Rezoning Transportation Analysis

Petition Number: 2022-121

From: Jake Carpenter, PE
Jacob.carpenter@charlottenc.gov
980-221-5675

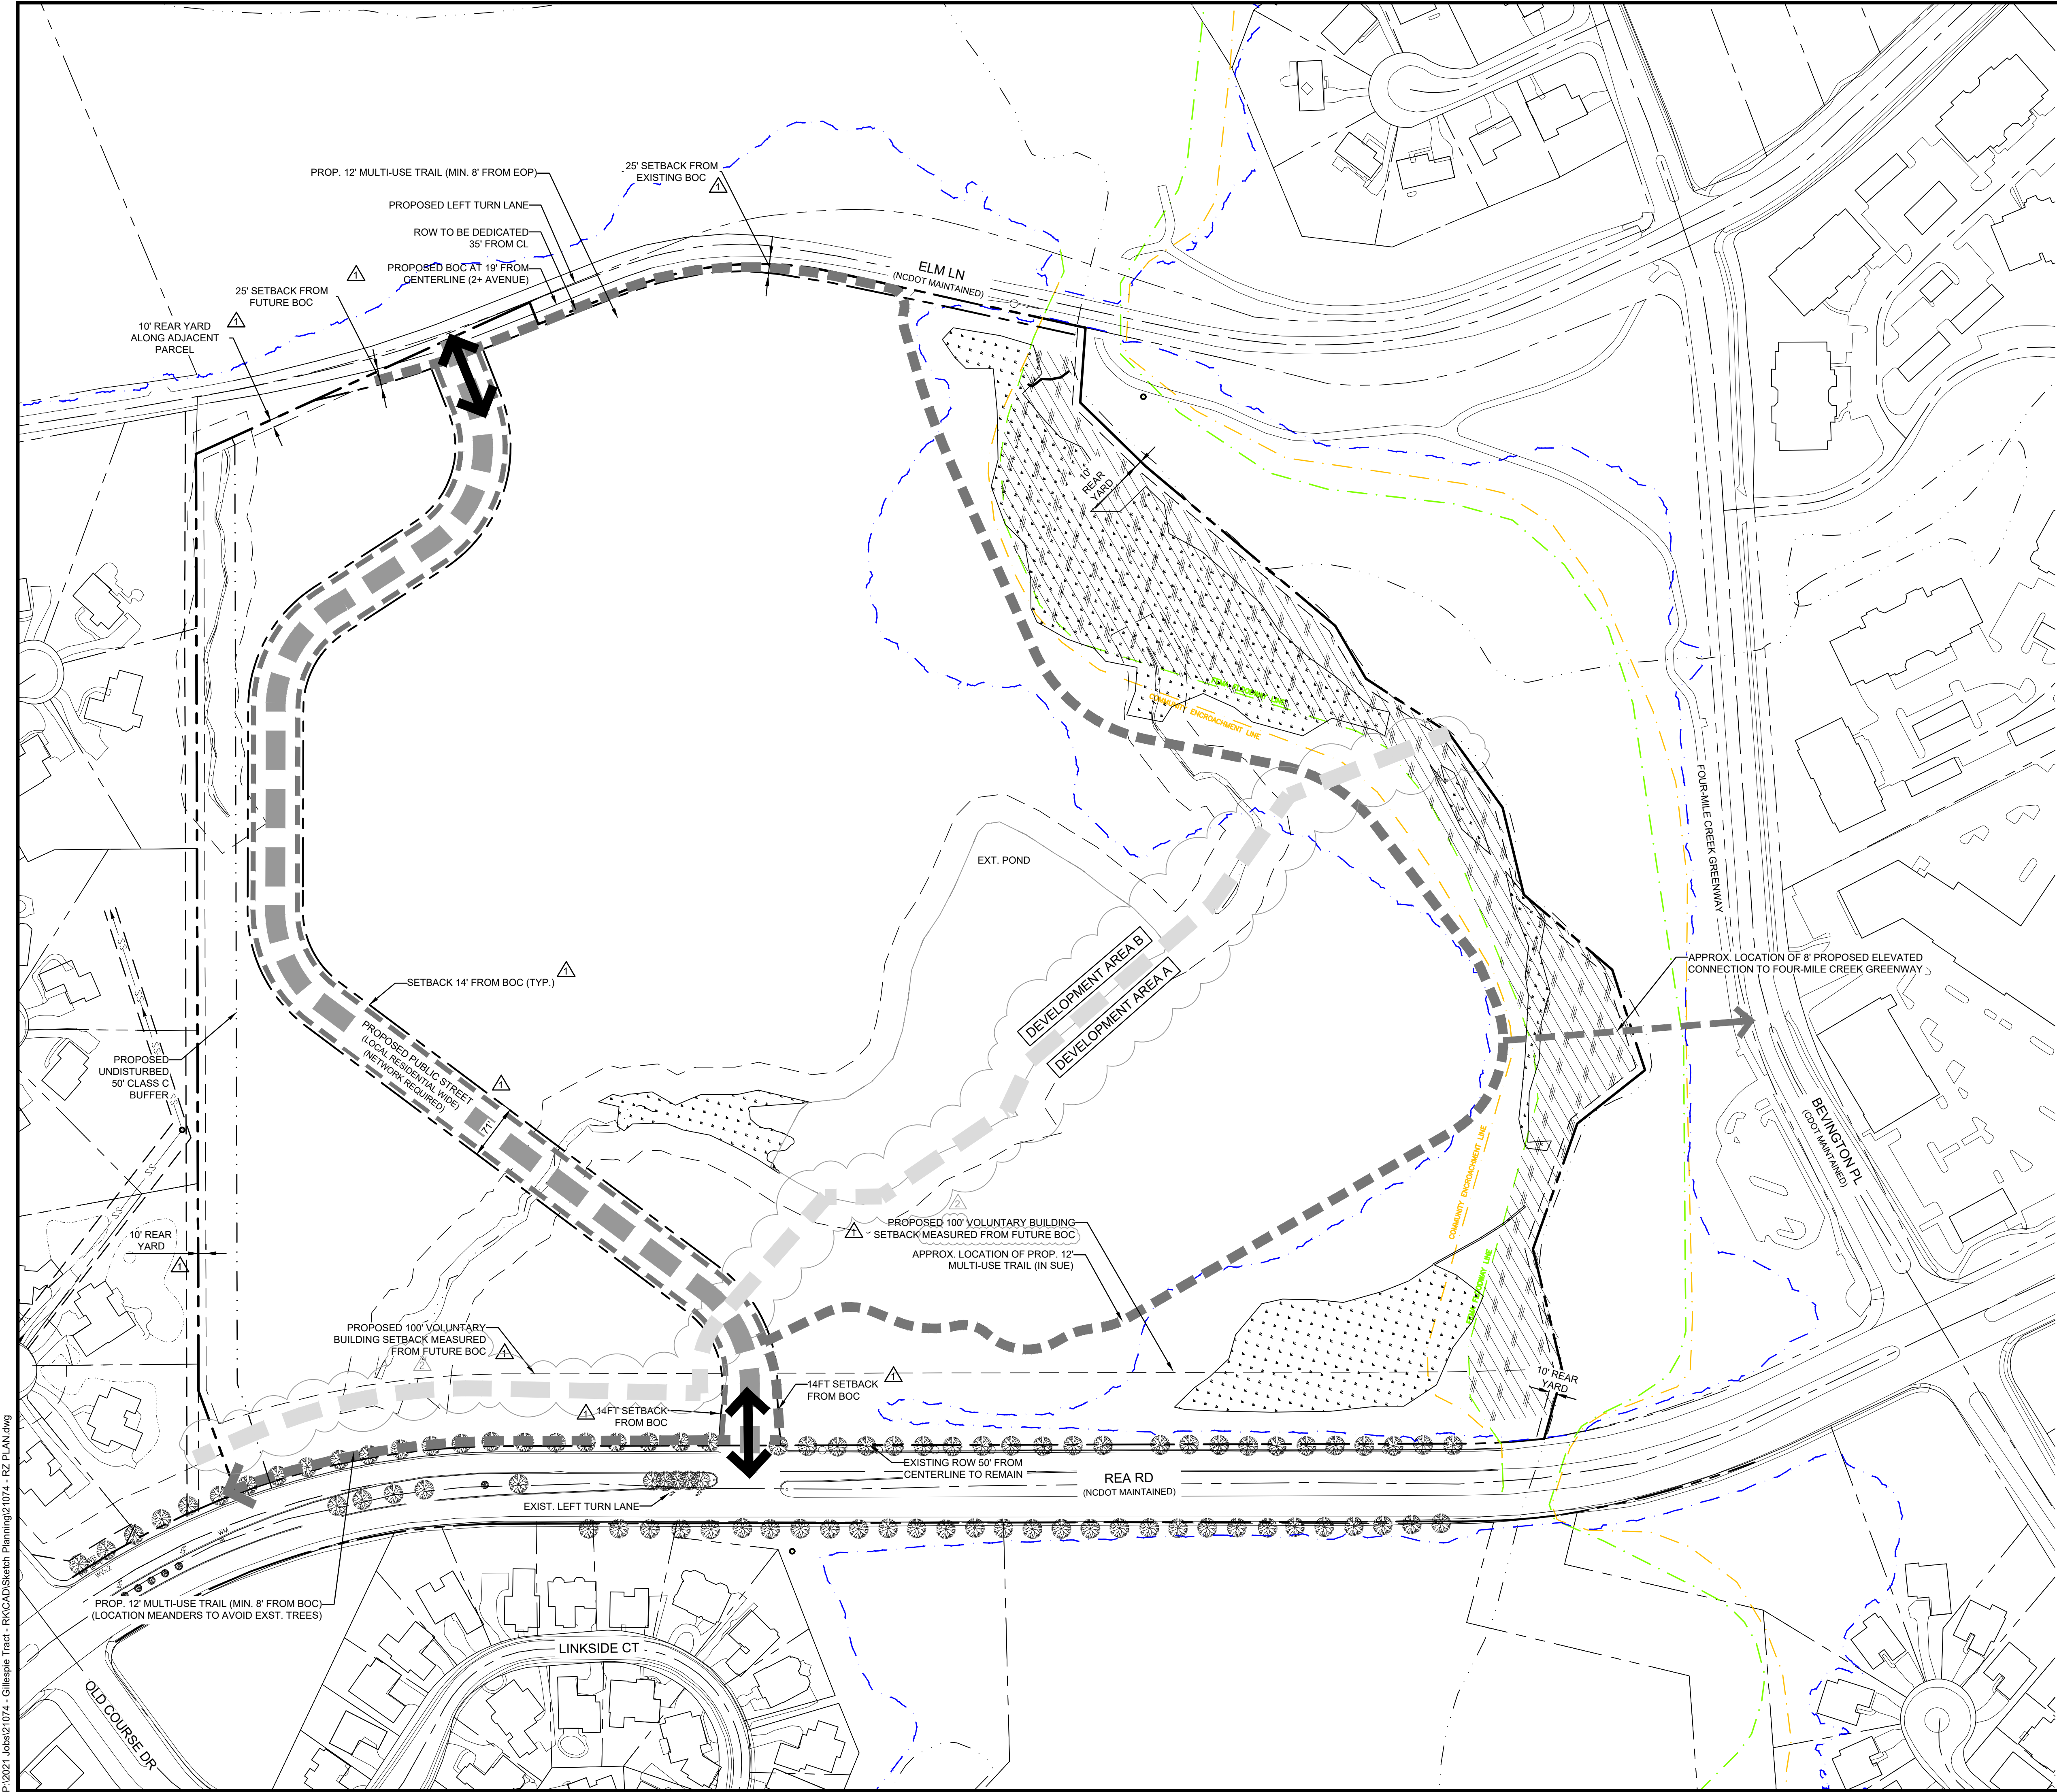
Clarifying Comment from 2/22/2023: Show MUP along Rea Road as shown above. We can work through the technical aspects in permitting as well as any necessary adjustments or exceptions to the required path.

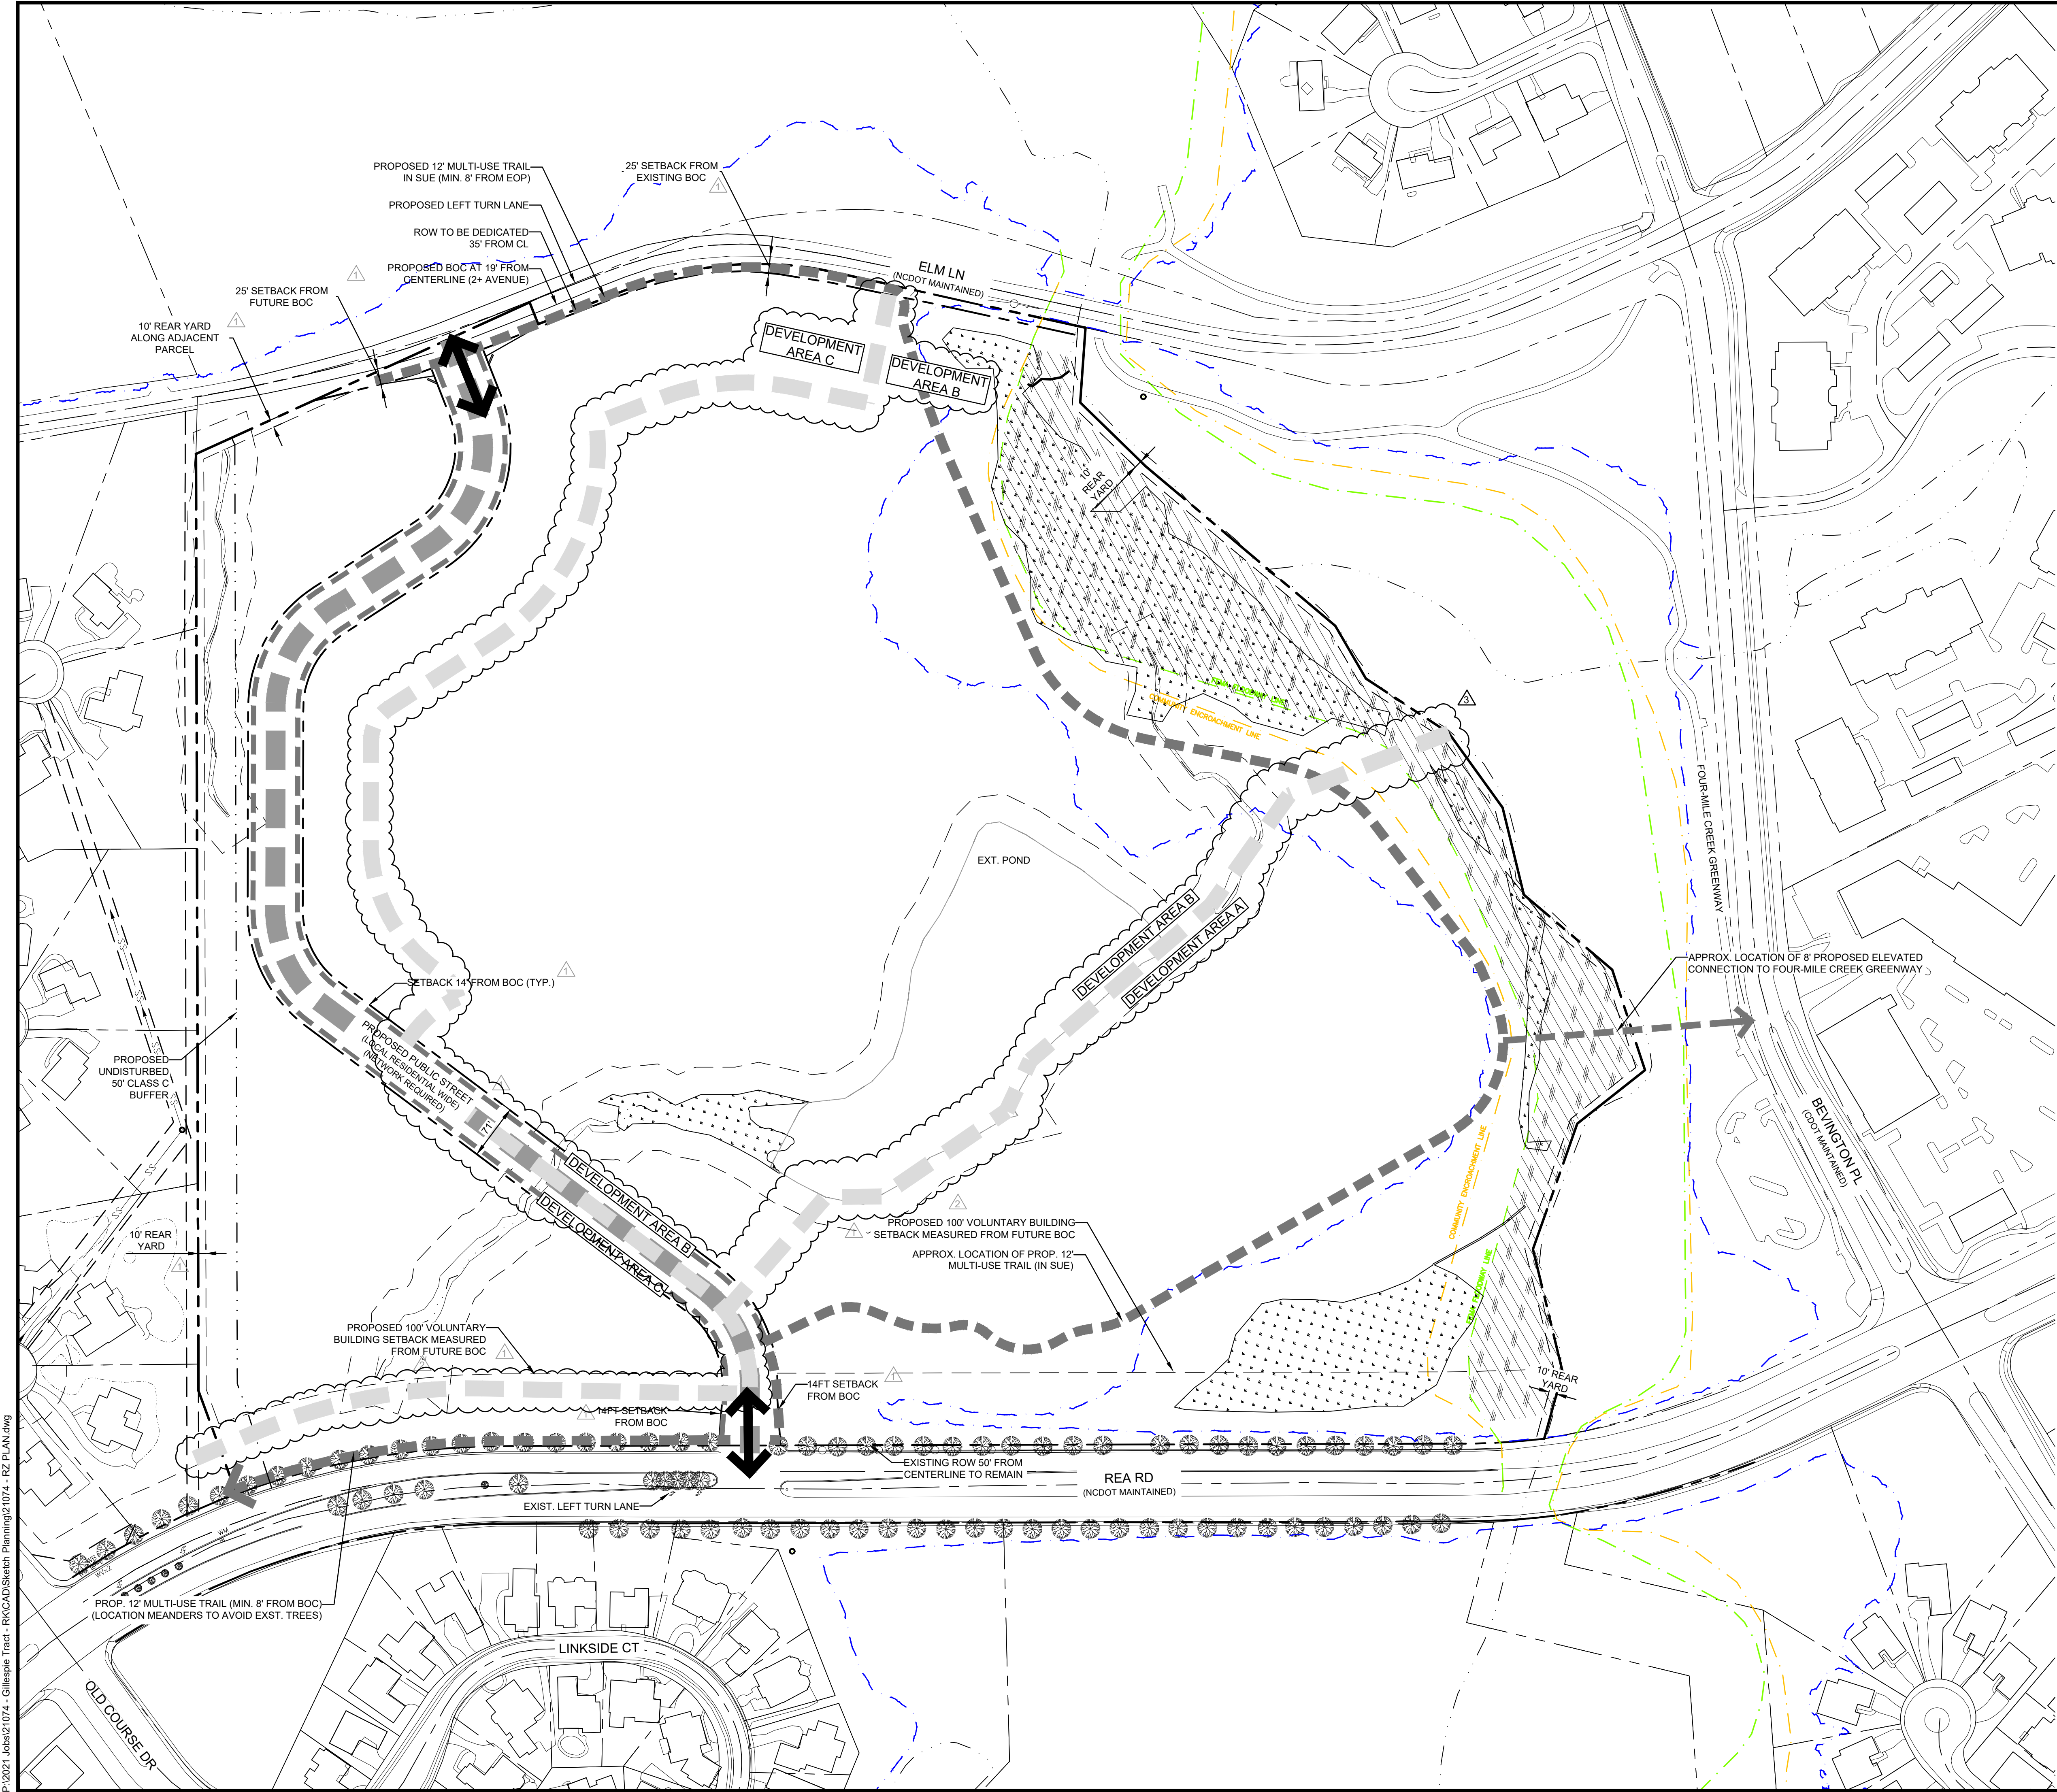
Update Comment from 8/23/2023: MUP needs to follow Rea Road for a greater distance. Engineering documentation needs to be provided to allow the required streetscape (MUP) to be constructed onsite.
